# CITY OF ALBUQUERQUE

March 6, 2019

**RE: Fire Station #9**  
**Conceptual Grading and Drainage Plan and Drainage Report**  
**Engineer's Stamp Date: 03/20/2019**  
**Hydrology File: H20D043**

C-100

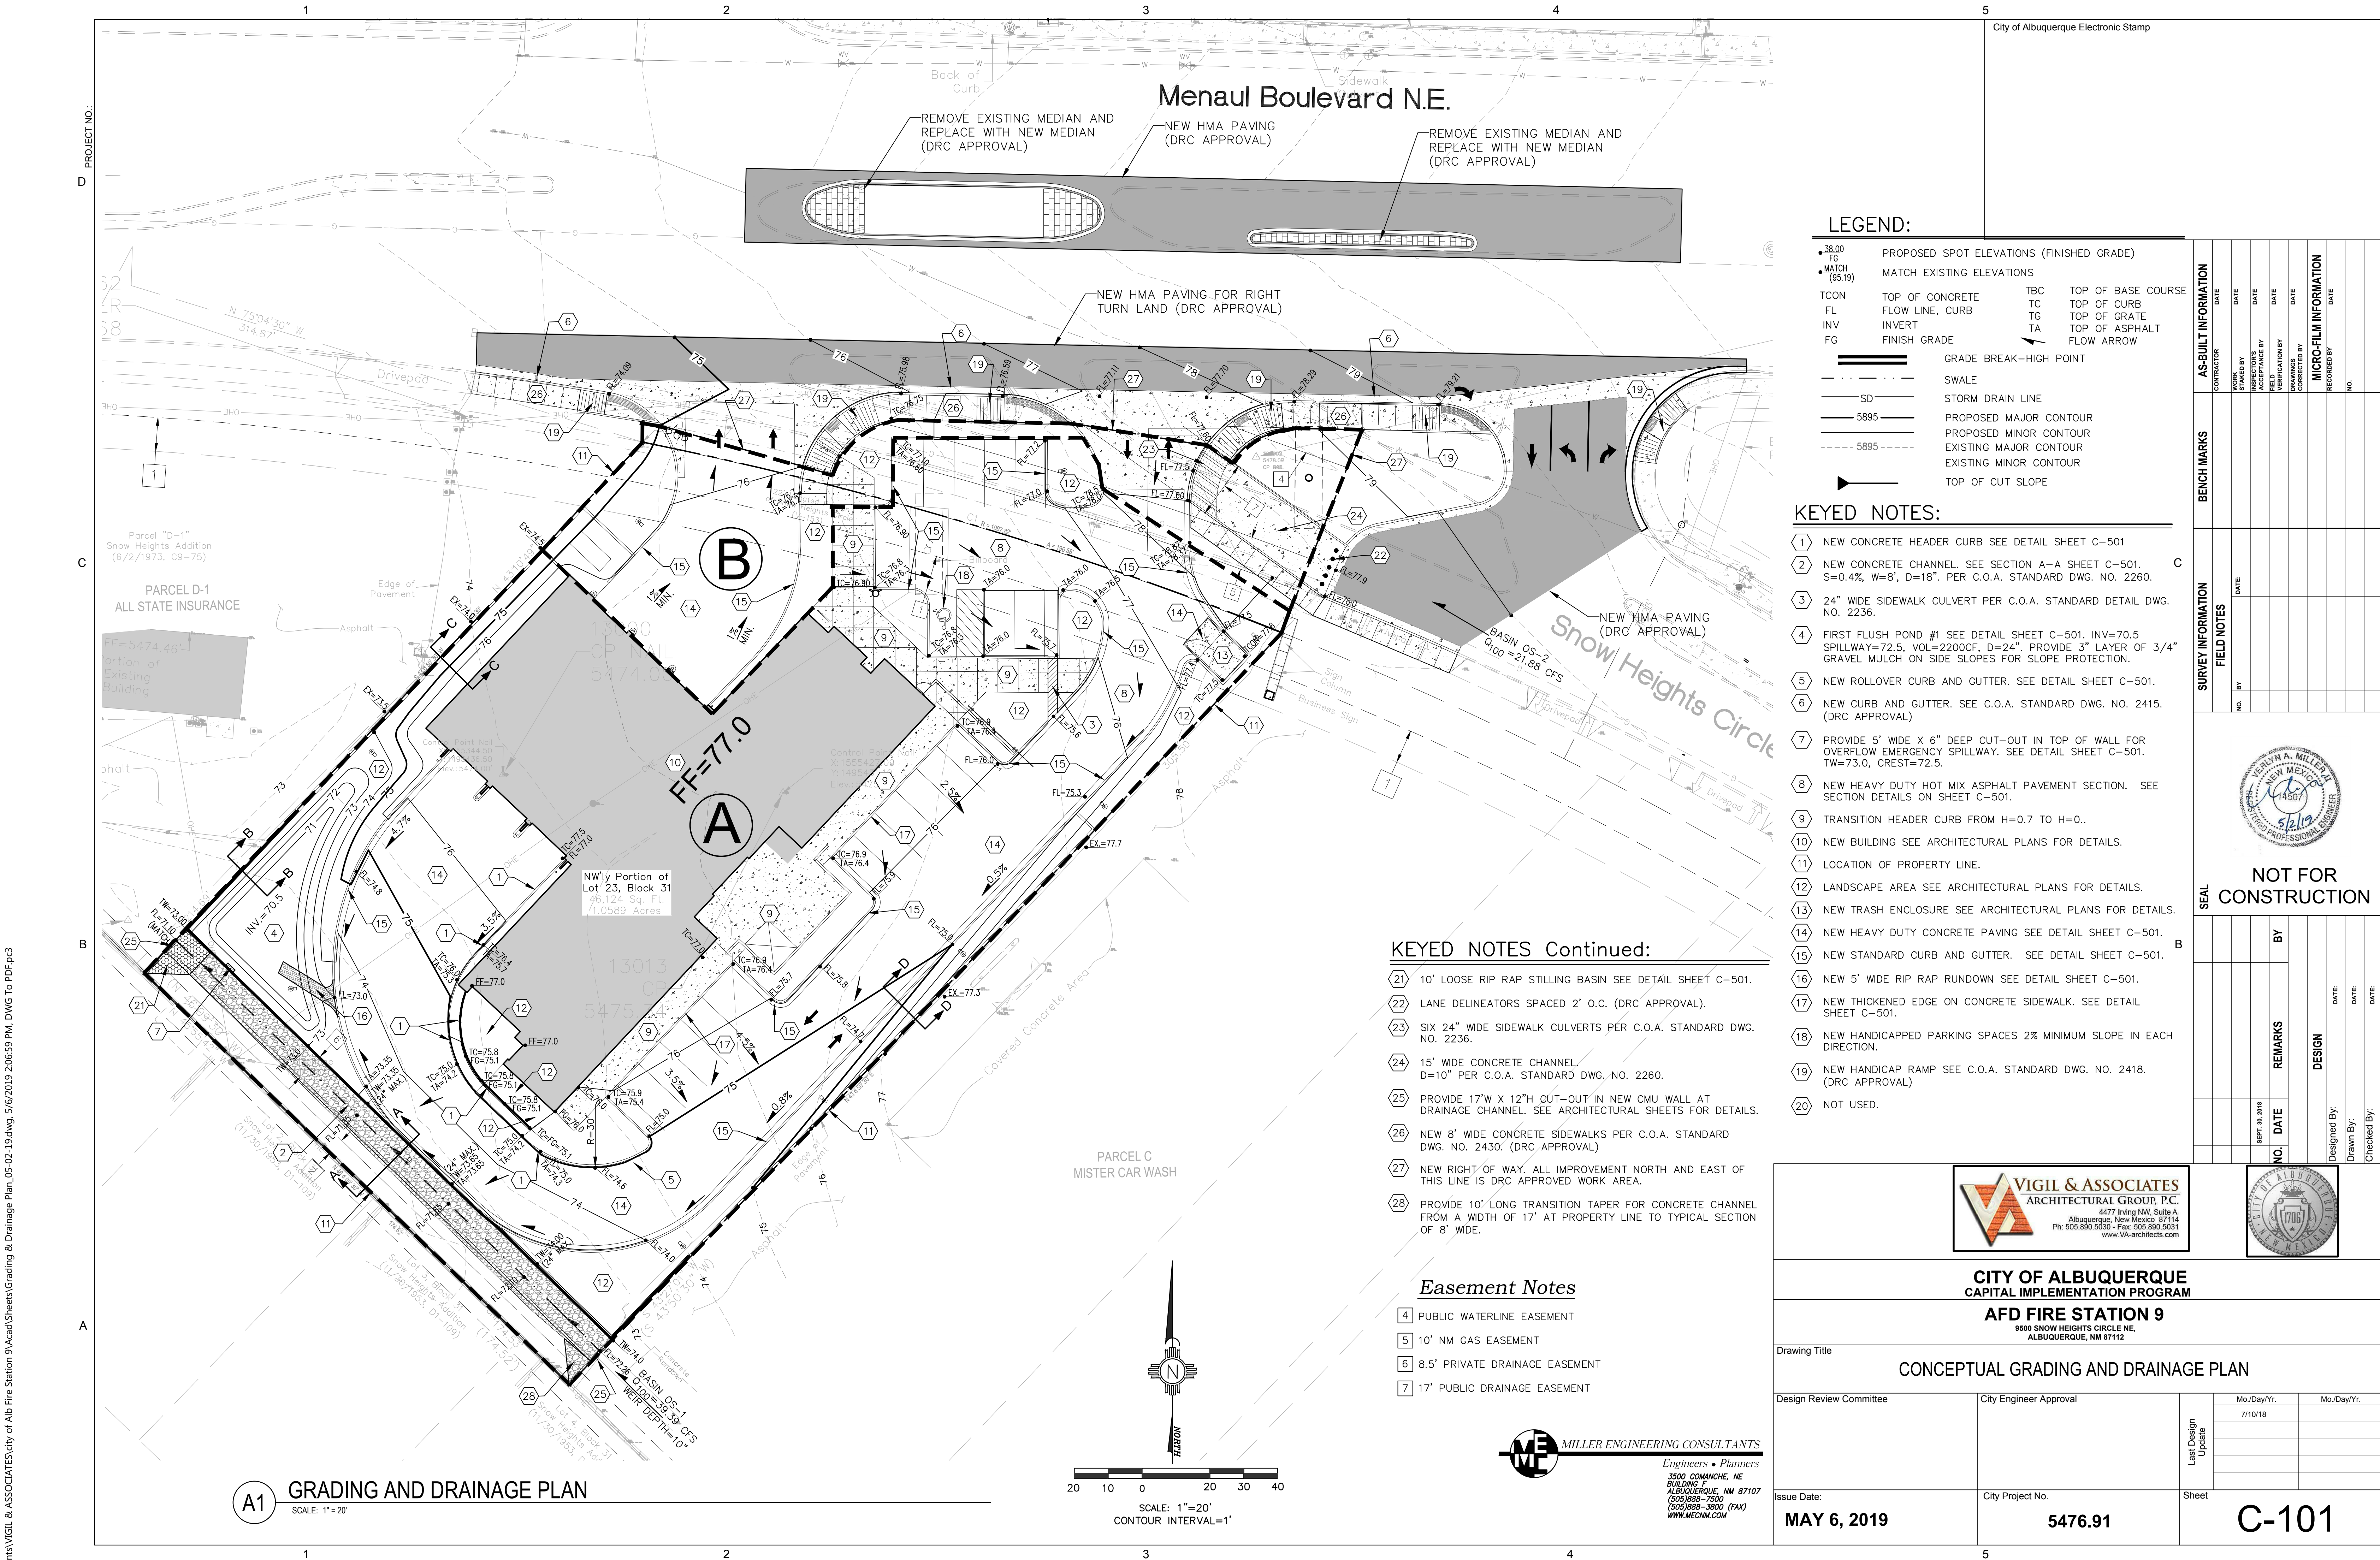
1. At the south channel entrance please specify an unobstructed opening in the perimeter wall for the required height. Provide details of a self-cleaning screen if any is proposed to cover the opening.

2. Please label the Stormwater Quality Volume (SWQV) required, the SWQV provided, the BMP elevation, and the 100 Year elevation on the plan view of each BMP Pond.

- a. Basins boundaries need to be shown on the G&D Plan around the area draining to each BMP, and the BMP should be sized for the required SWQV of the area draining to it.

- b. Credit in excess of the required SWQV for the area draining to each BMP is not allowed. An additional BMP pond or infiltration trench is recommended in the northwest corner of the site to provide onsite treatment of all the required SWQV for this site, or the owner may elect "Payment in lieu" of construction of the required SWQV. How is Basin B SWQV being provided?

- c. The 100 year elevation of each BMP pond should be far enough below the top of dam elevation to allow freeboard for construction tolerances and settlement.

- d. The crest elevation of the overflow spillway should be set far enough above the required BMP elevation to allow freeboard for construction tolerances and settlement.

- e. Please specify the width and depth of each structure along with the peak 100 year flow rate and the weir depth calculation for each spillway and rundown into the ponds. Please correct key notes 7 and 16 to match the weir calculations.

4. Additional grading information is needed:
  - a. The height of the water block on the east driveway should be increased to 0.87' minimum per DWG 2426 and should be measured perpendicular to the flow.

- b. Contours need to reflect the grade change across C&G.
  - c. Contour 75 should not cross the west driveway but should instead connect to the existing 75 contour in the street.

- d. More spot elevations are needed around the building, in the front and east parking lot, and along Menaul Blvd at C&G and back of sidewalk.
  - e. The grade 76.3 at the front parking sidewalk culvert appears too high to drain.

- f. Consider reducing all of the pond slopes to 3:1 or specify stabilization techniques on the G&D Plan per DPM 22.5(A).
5. Recommend bringing DRC plans to at least 50% complete before seeking G&D approval for Building Permit and Work Order so the interface between this site and the Public Infrastructure is understood better.

C-503

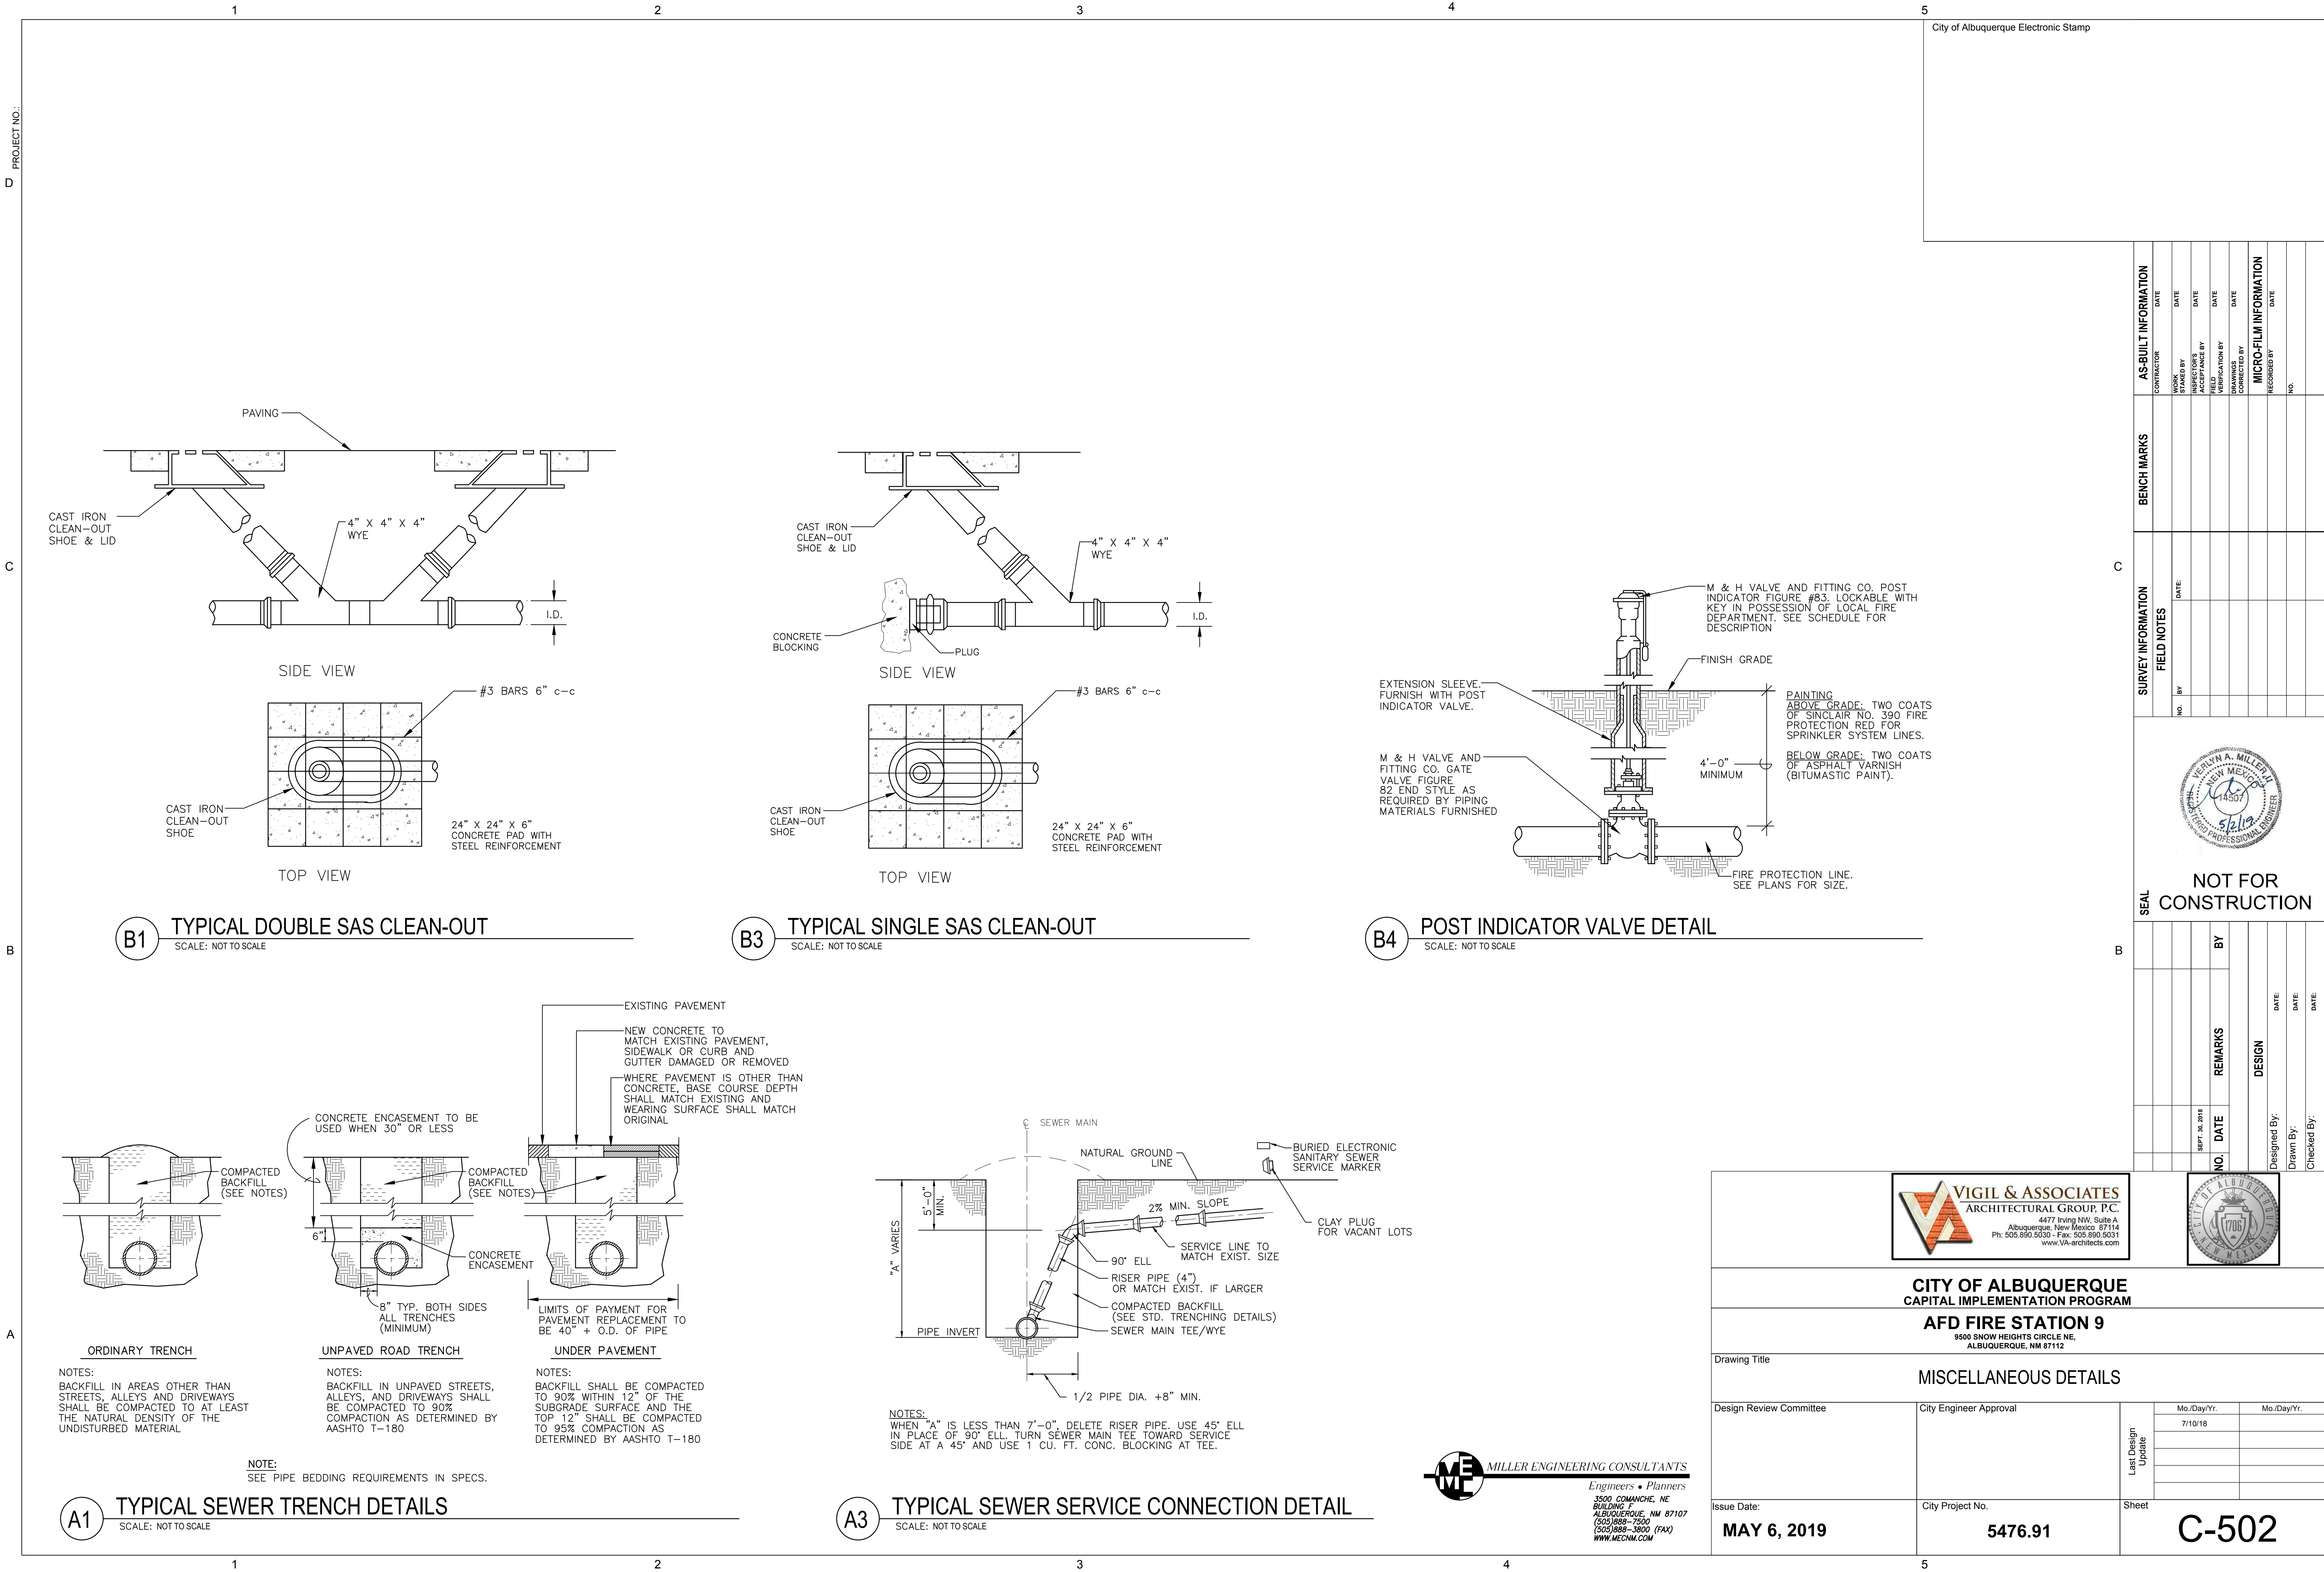
3. Thanks for adding the typical sections on Sheet C-503, see comments below:
  - a. Show the existing block wall in Section A-A and show the existing ground on the adjacent lot at about the same elevation as the invert of the new channel. Please consider allowing low flows from the channel to seep into the area between the channel and the wall on the property line. The plan view shows the existing wall centered on the lot line but the section shows the wall entirely on this site. Is the existing wall to remain? Will there be any grade change across the wall? New wall footings must not encroach into adjacent property without written permission from the neighbor.

- b. In Section B-B the soil against the wall will likely be saturated so please note that the structural design should accommodate saturated soil.
  - c. Please show the perimeter wall in section C-C and consider adding 2' of retaining to flatten the slope between the wall and the building. The existing slope exceeds 3:1. Please specify the slope between the wall and the building on the section and spot elevations to the plan view on both sides of the wall. Adjust contours accordingly. on the plan view so that the slope does not exceed 3:1.

- d. There appears to be 1' to 2' foot of retainage across the wall in Section D-D that should be reflected in the section. Spot elevations on both sides of the wall should be added to the plan. The landscape strip between the wall and the parking lot could easily be graded flat to provide more SWQV if the south pond is not big enough.
